**CITY OF ALBUQUERQUE
PLANNING DEPARTMENT
April 11, 2012
DRB Comments**

ITEM # 17

PROJECT # 1009203

RE: Tract 202 A-1-B, MRGCD Map # 33

Proposed Subdivision of lot--4600 San Isidro NW

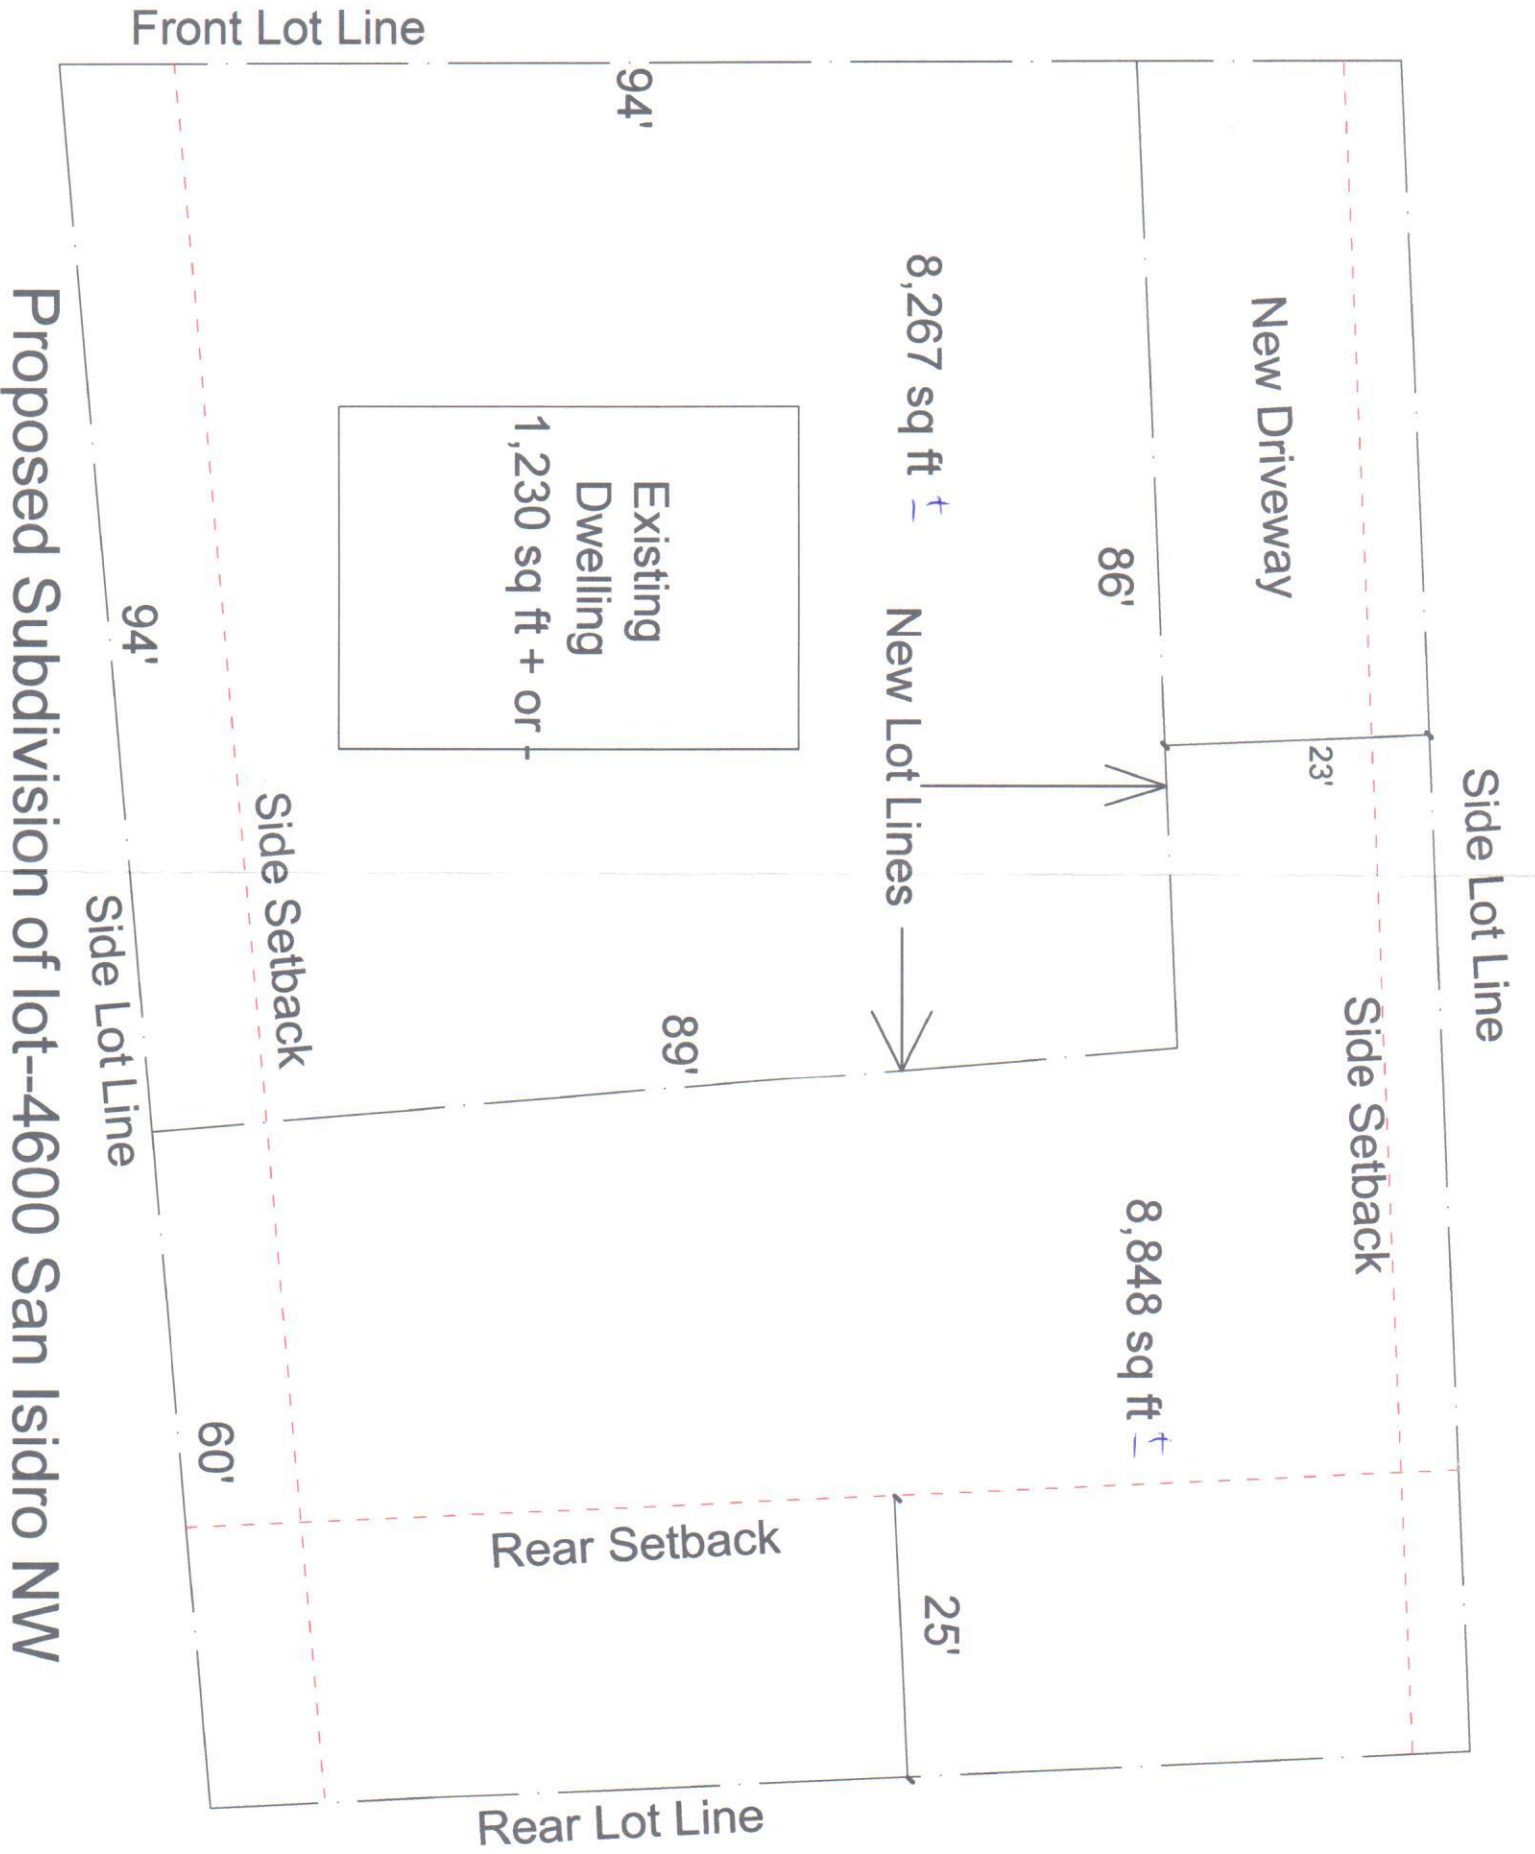
The site is zoned RA-2 which requires a minimum net lot area of 10,890 square feet. A lot size variance from the Zoning Hearing Examiner would need to be approved in order to subdivide this tract, and the subdivision would need to be prepared by a NM licensed professional land surveyor.

The driveway for the proposed rear lot would need to be an easement over the front lot – it cannot be part of the proposed rear lot because it would create what is known as a flag lot. The easement square footage would have to be subtracted from the front lot to determine the net lot area.

Zoning Enforcement should be consulted regarding setbacks; it appears the proposed rear lot may need to be oriented with the 'front' to the north and the rear setback would be on the south side. If a lot size variance is approved, Zoning Enforcement will need to verify a pad site that meets the setback requirements before the subdivision could be approved.
